Re: Narrabri Gas Project

This letter was prepared in response to your request, on behalf of the North West Alliance, to provide independent expert advice regarding the Narrabri Gas Project. That request was the subject of the letter that I received from you dated 31 March 2017.

As requested by you, I have now reviewed the following sections of the Environmental Impact Statement (EIS) for The Narrabri Gas Project ("project"), prepared by the project proponent, Santos.

Figure 1: Summary of Water Treatment Process

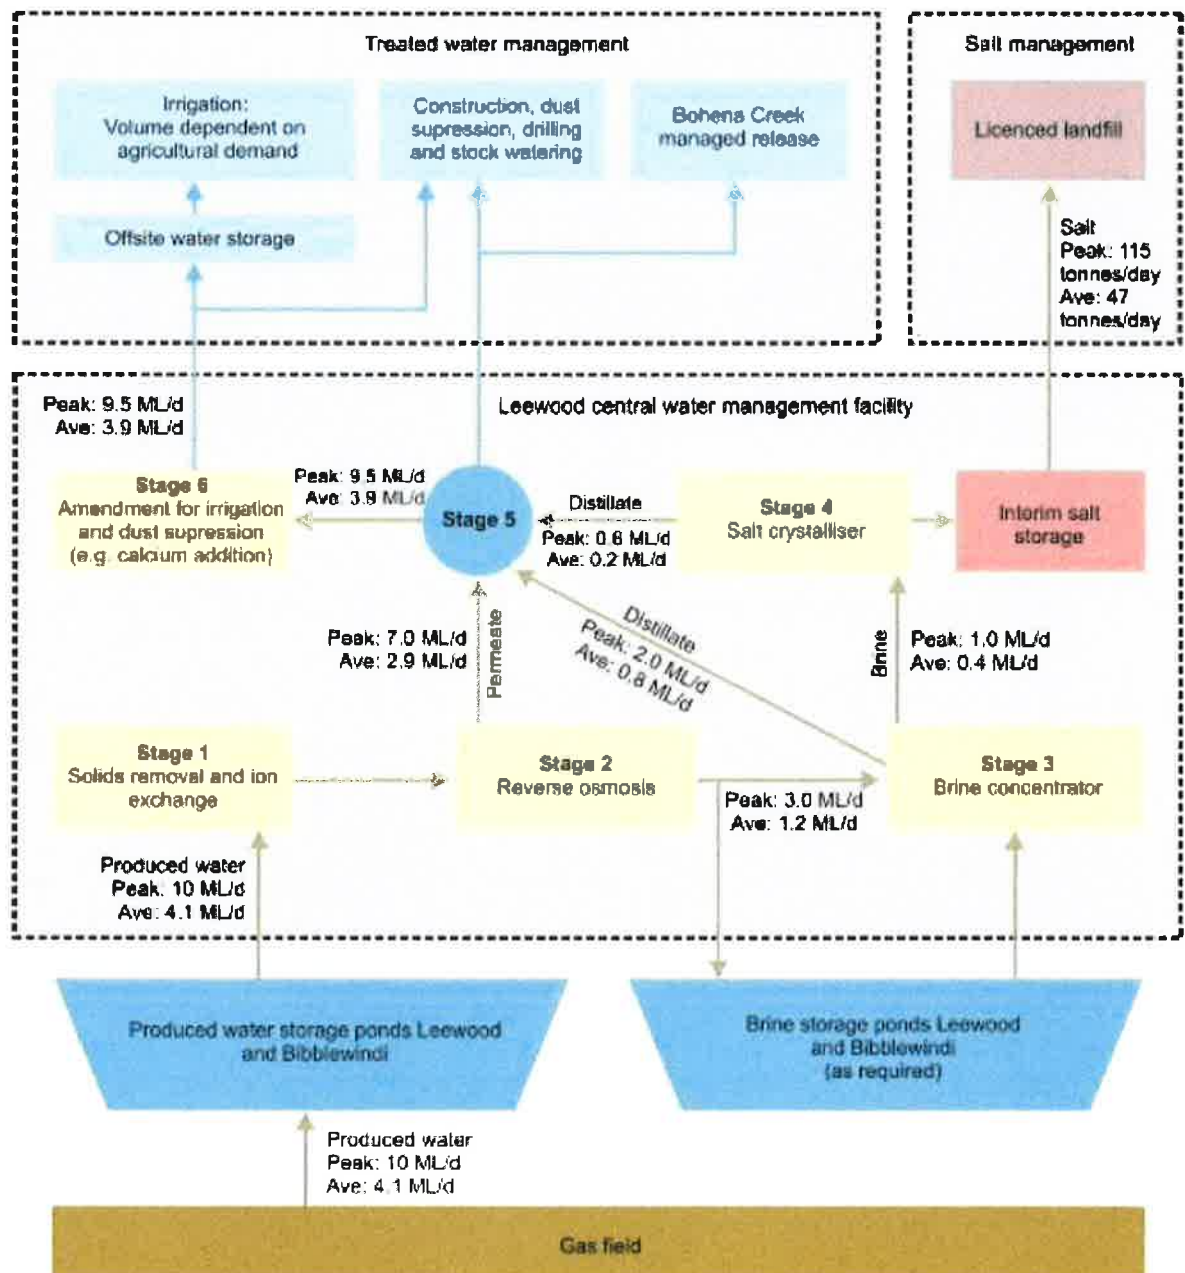
The overview of the water treatment process (Figure 7-4) indicates that significant volumes of brine concentrator distillate and salt crystalliser distillate will be blended with RO permeate. I have not identified information describing the expected water quality of these distillates. If they are significantly lower than that of RO permeate, it may be more appropriate for those distillates to be blended into the RO feed, rather than the RO permeate.
